**Land at Junction 10, M40**  
**Landscape and Visual**  
**Impact Assessment -**  
**Review**

Prepared by LUC

January 2022

**1.1** LUC has been commissioned by Cherwell District Council (CDC) to provide advice on landscape and visual matters relating to the submission of three planning applications - one submitted in detail and two submitted in outline – (21/03266/F; 21/03267/OUT; and 21/03268/OUT) for the development of storage and distribution buildings with associated access and internal roads (the ‘Development’) on land at Baynard’s Green near Junction 10 of the M40 (the ‘Application Site’). This has included a site visit (07 January 2022) and attendance at a meeting with CDC (26 January 2022).

Drawing Title: **PARAMETER PLAN 08
VEGETATION RETENTION
& REMOVAL**

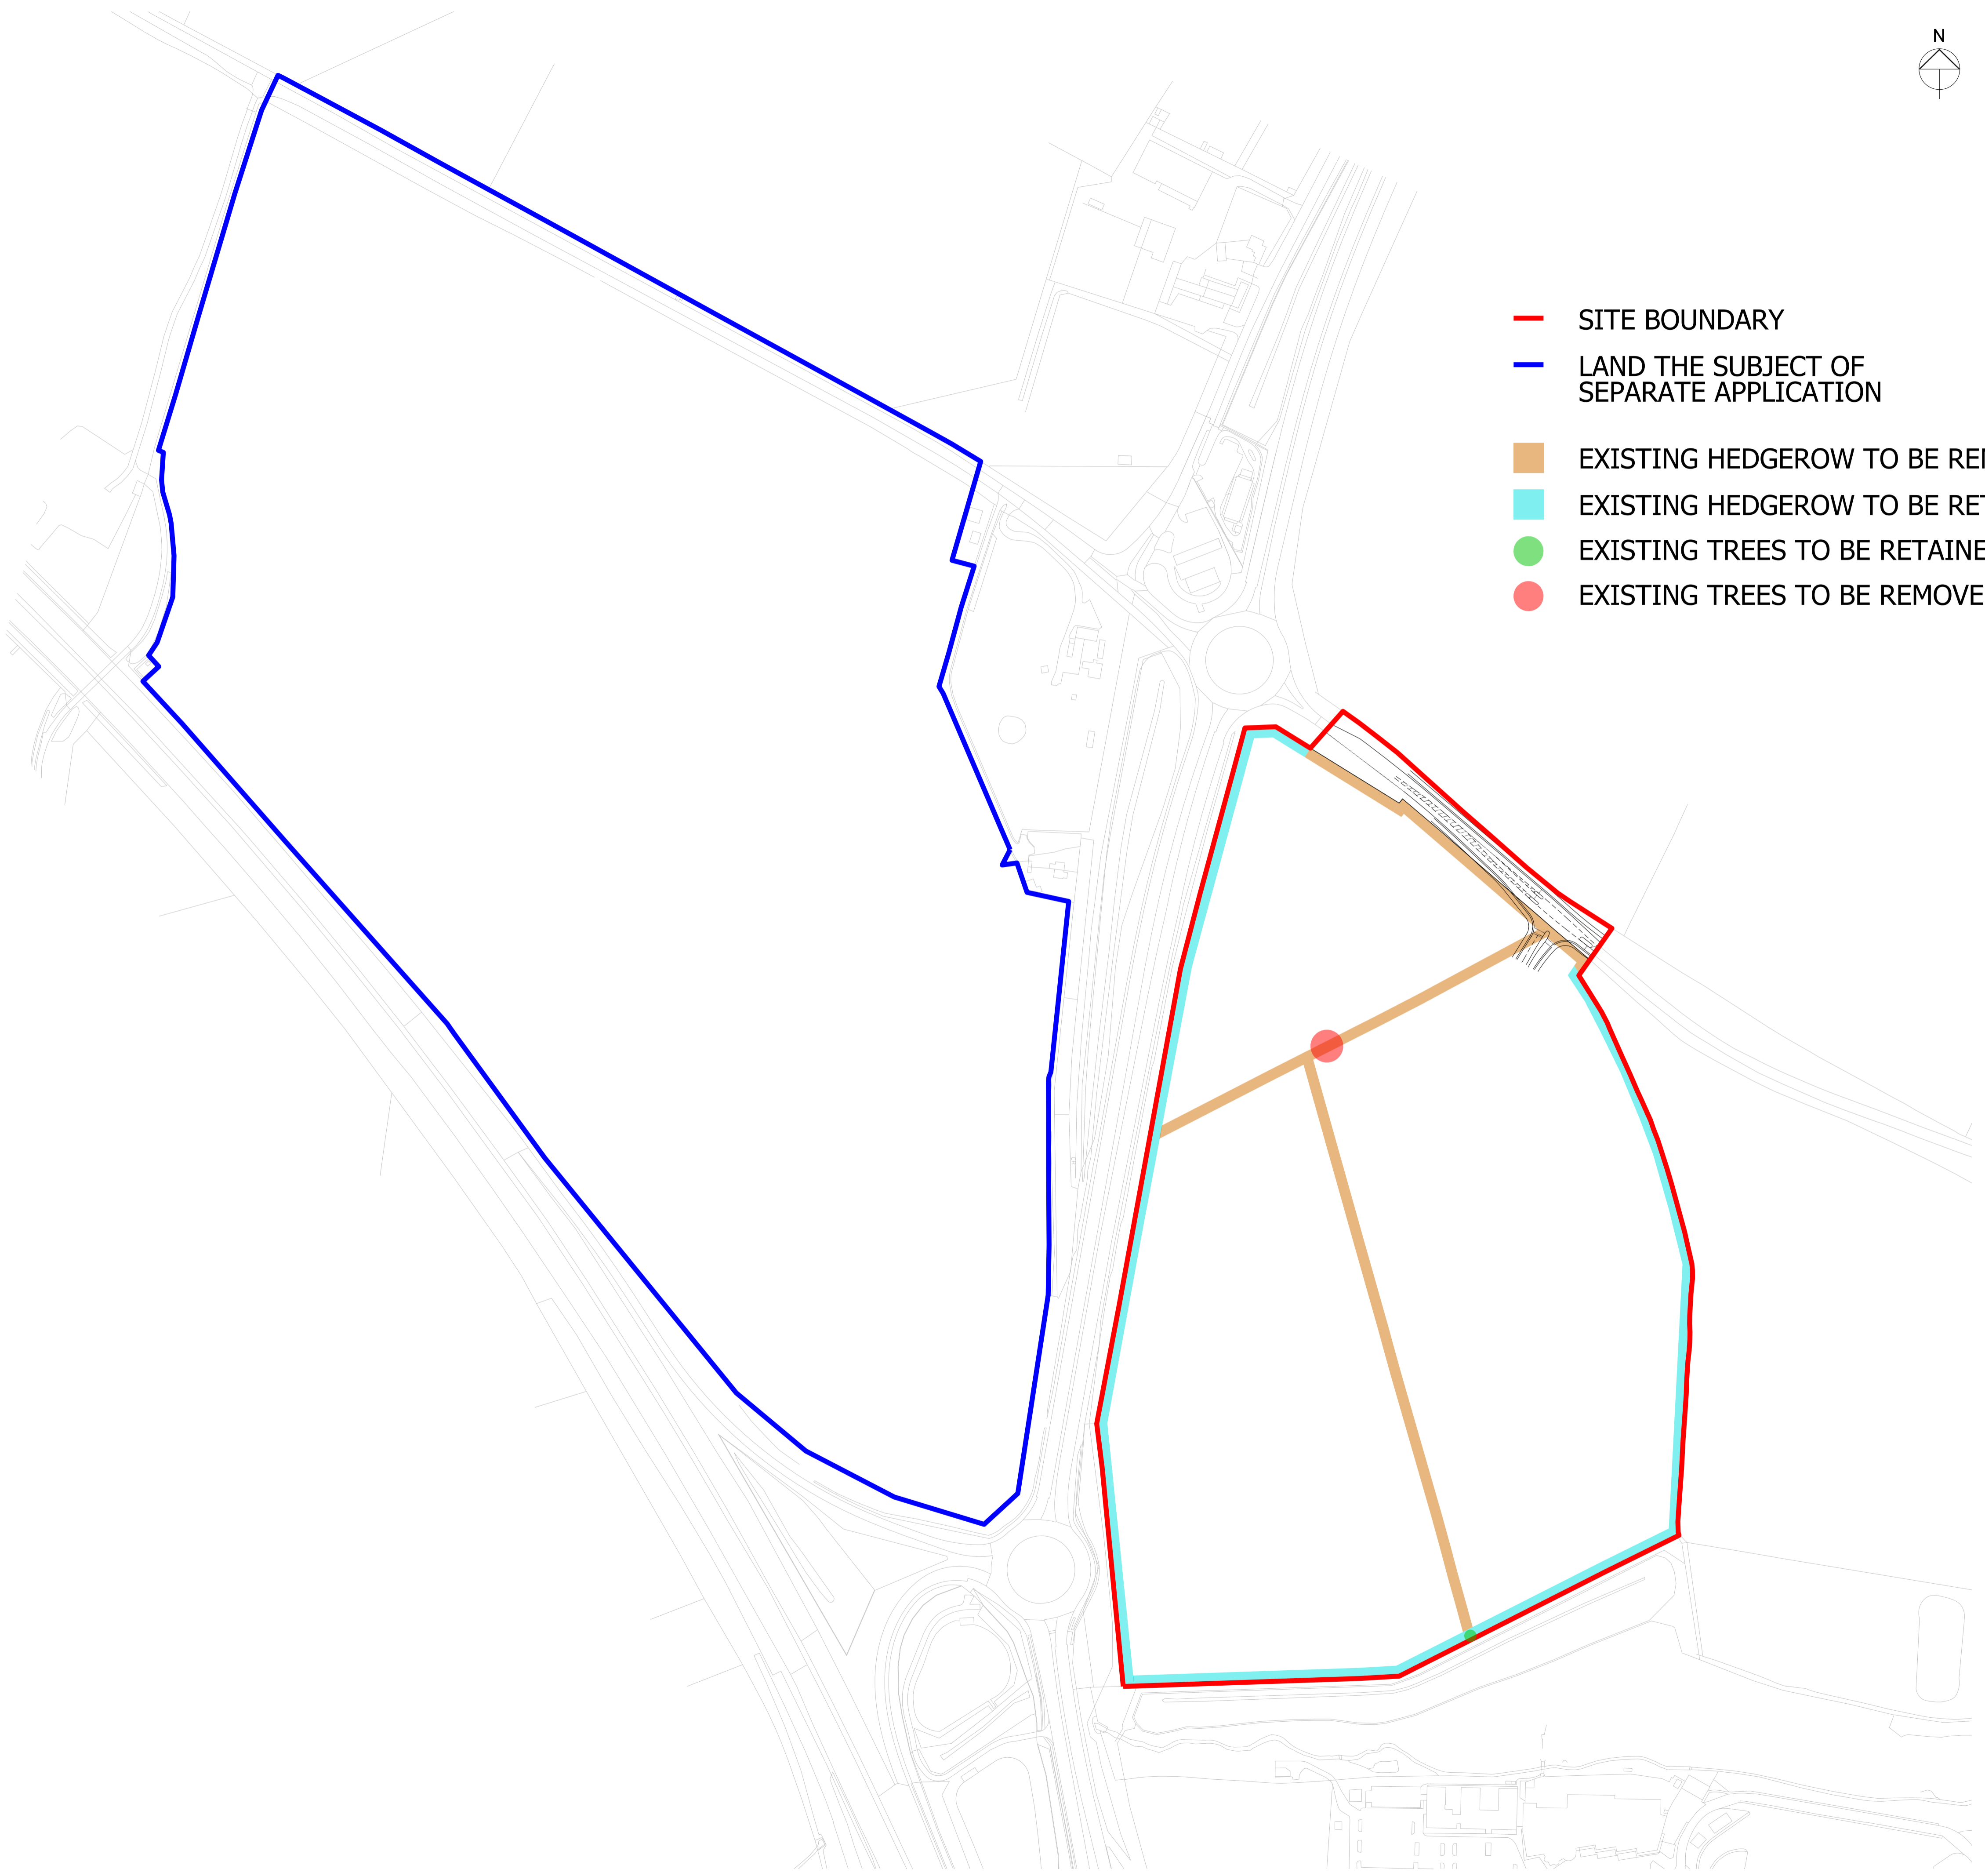
**2.24** We feel that some of the effects during the enabling works have been under reported. For example, it is concluded that there would be no views of the works available to users of the PRow network to the east and north of the Site, however based on Photoviewpoint 10 and LUC's site visit, some filtered views are likely to be available, particularly where vegetation removal will occur along the B4100 (as shown on Parameter Plan 03).
